KIRKLEES METROPOLITAN COUNCIL INVESTMENT & REGENERATION SERVICE

DELEGATED DECISION TO DETERMINE APPLICATIONS FOR LISTED BUILDING CONSENT

Reference No:	2025/65/90425/W
Site Address:	89, New North Road, Edgerton, Huddersfield, HD1 5ND
Description:	Listed Building Consent for installation of 4 CCTV cameras (within a Conservation Area)
Recommending Officer:	Edward Cheseldine

2025/90425 - 89, New North Road, Edgerton, Huddersfield, HD1 5ND

PROPOSED SITE PLAN

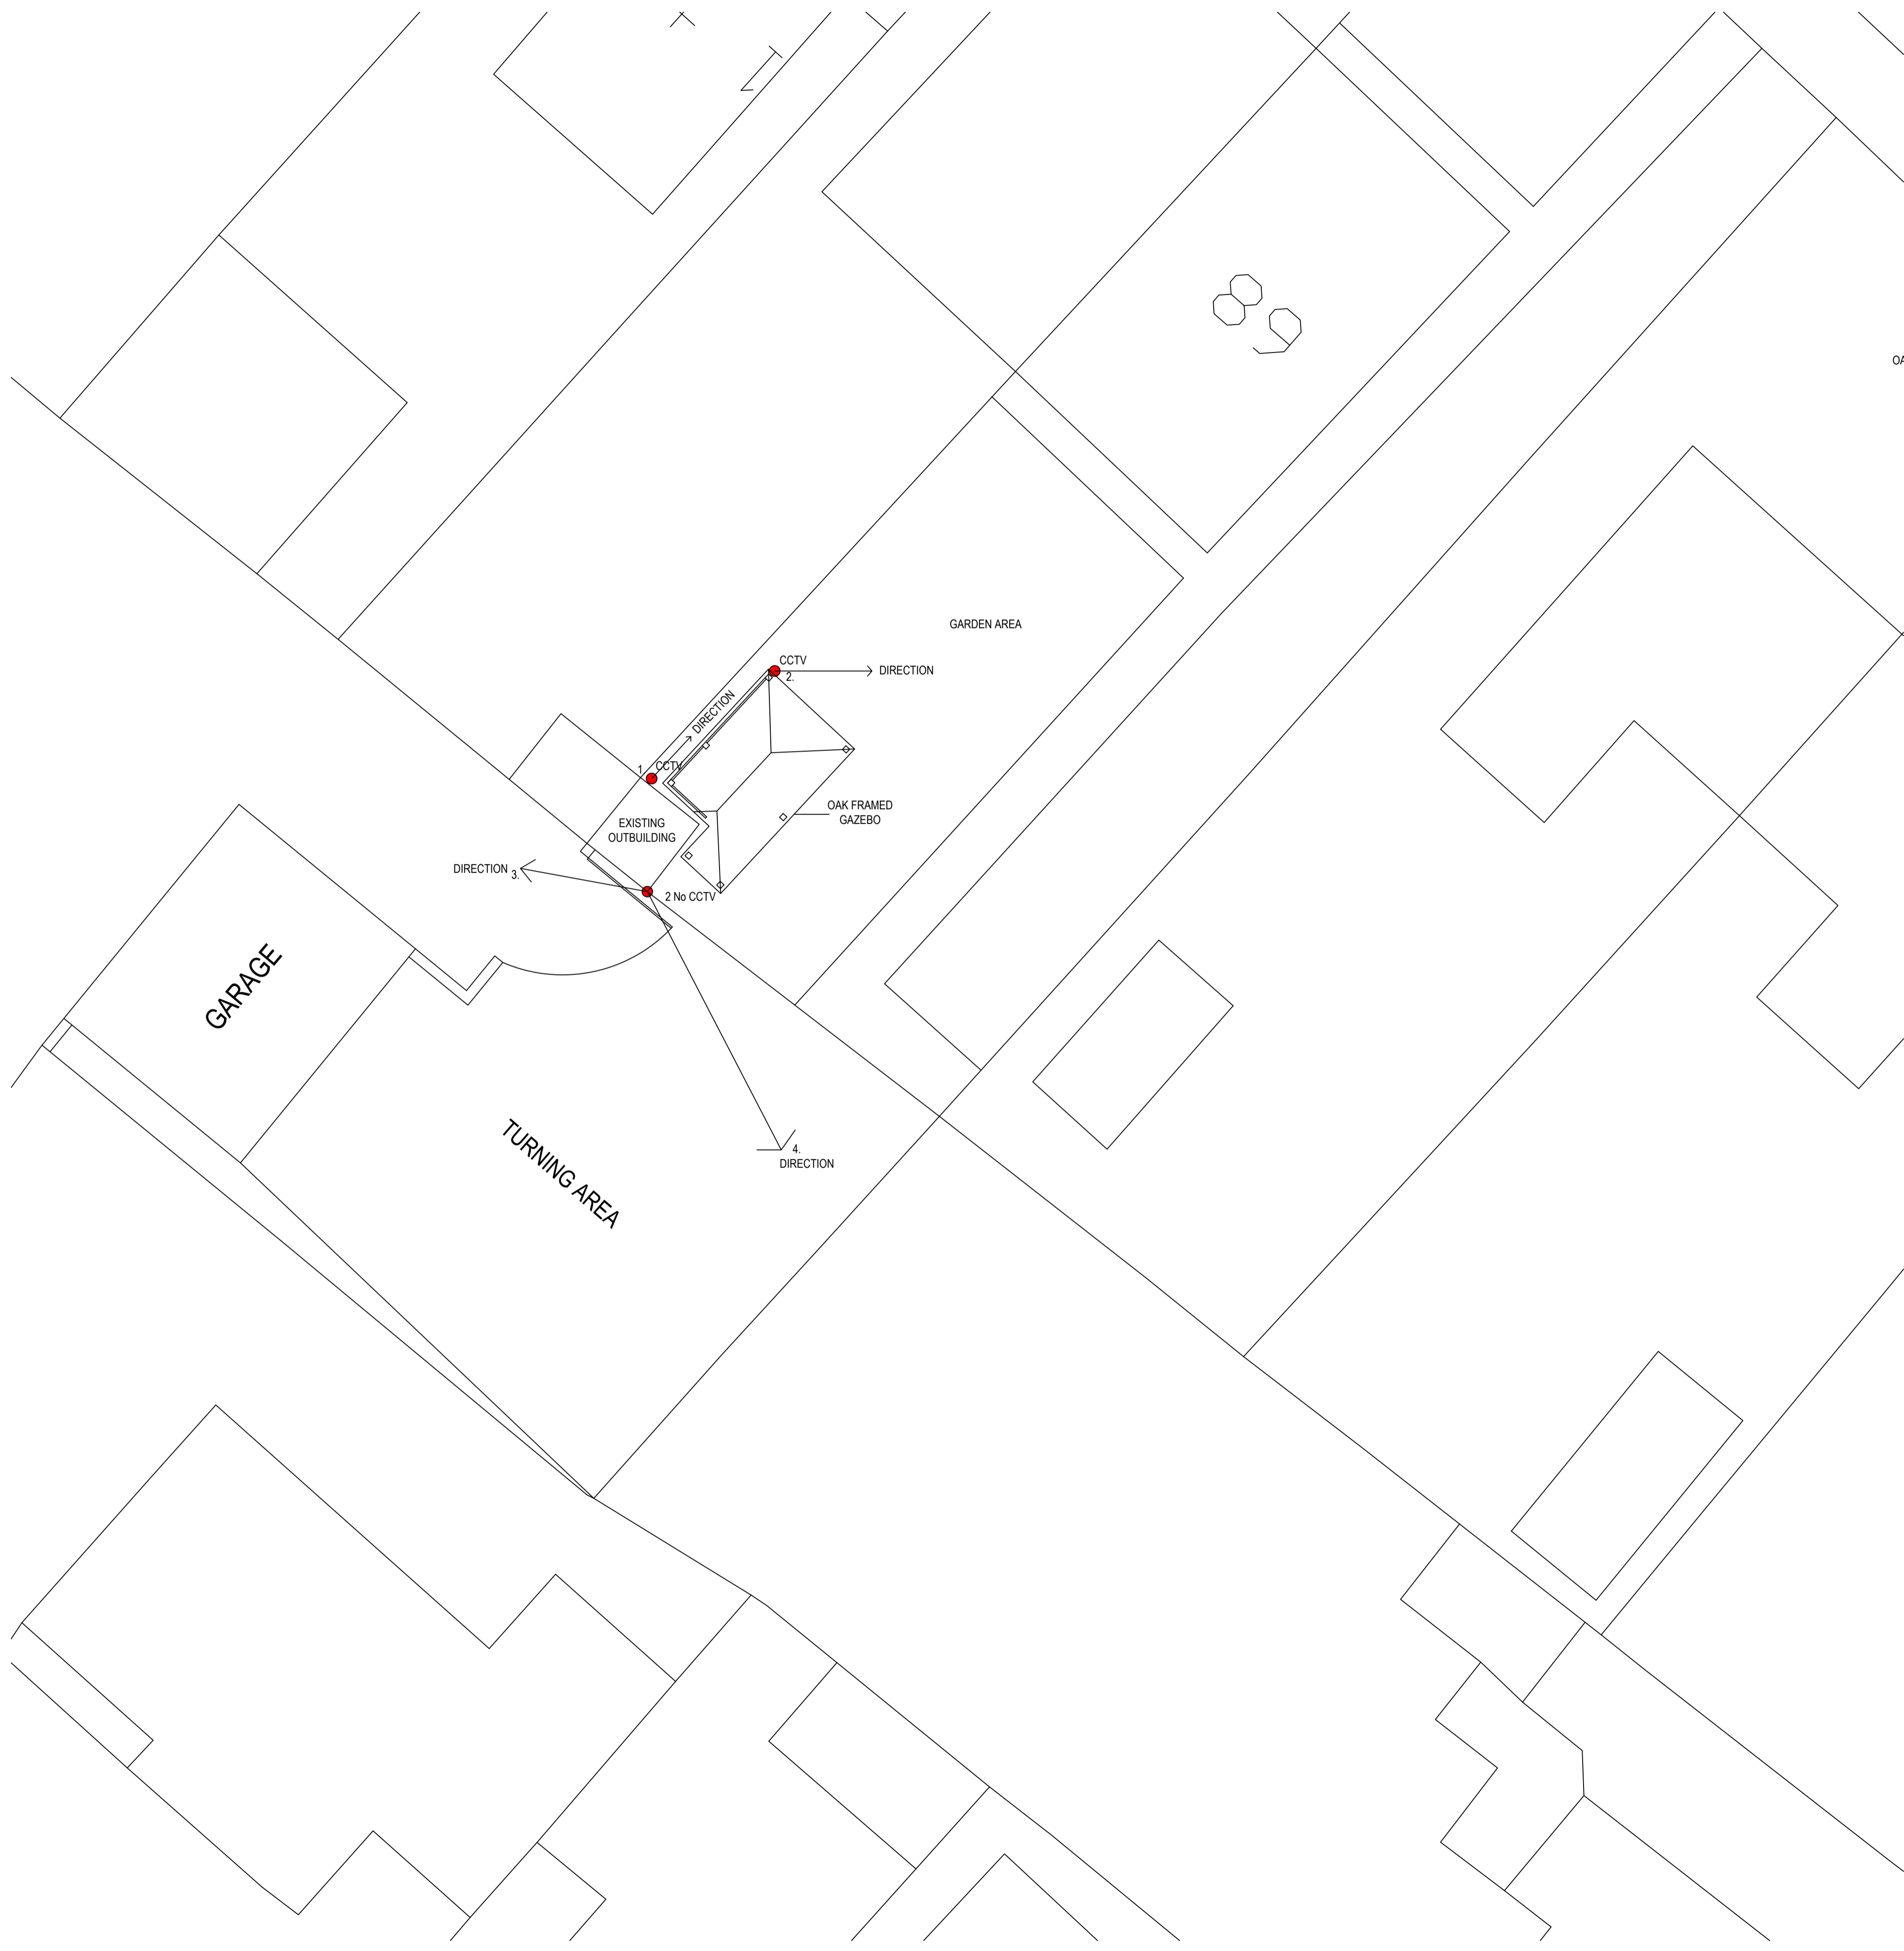
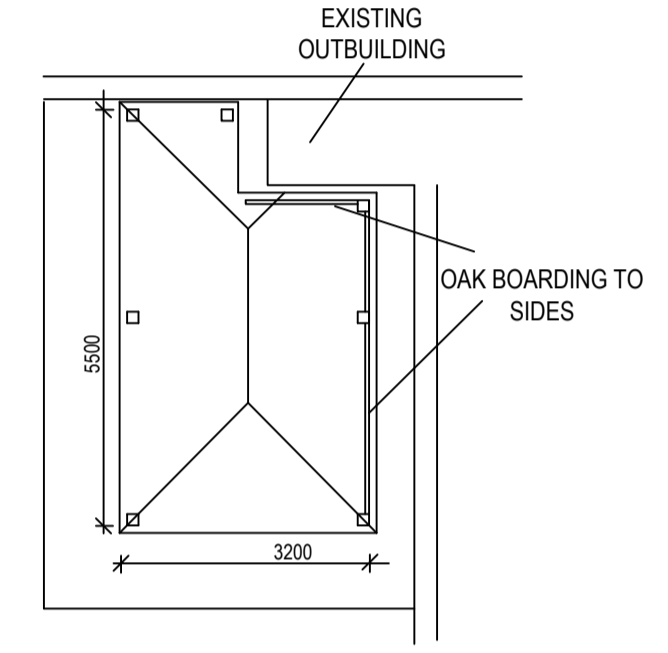
Camera 1: Fixed to original wall through mortar joint.

Camera 2 fixed to canopy extension wooden post.

Camera 3 & 4 fixed to original wall.

CCTV is not an uncommon feature within the curtilage of residential dwellings. The security cameras are fixed at appropriate points away from the main listed building within the rear private area. Whilst cameras 3 & 4 are fixed into the masonry, it has been communicated to the application, all future fixings should go into mortar joints and consent sought prior to development. As the cameras are currently fixed, it would cause more damage to historic fabric to remove and reinstall cameras 3 & 4, therefore there is no objection to their placement. Camera heads are generally small and a black colour which is acceptable. The application has been accompanied by a statement, the applicant also detailed during a site visit there were private security concerns with the property. Works are minimal and the erection of security cameras is justified.
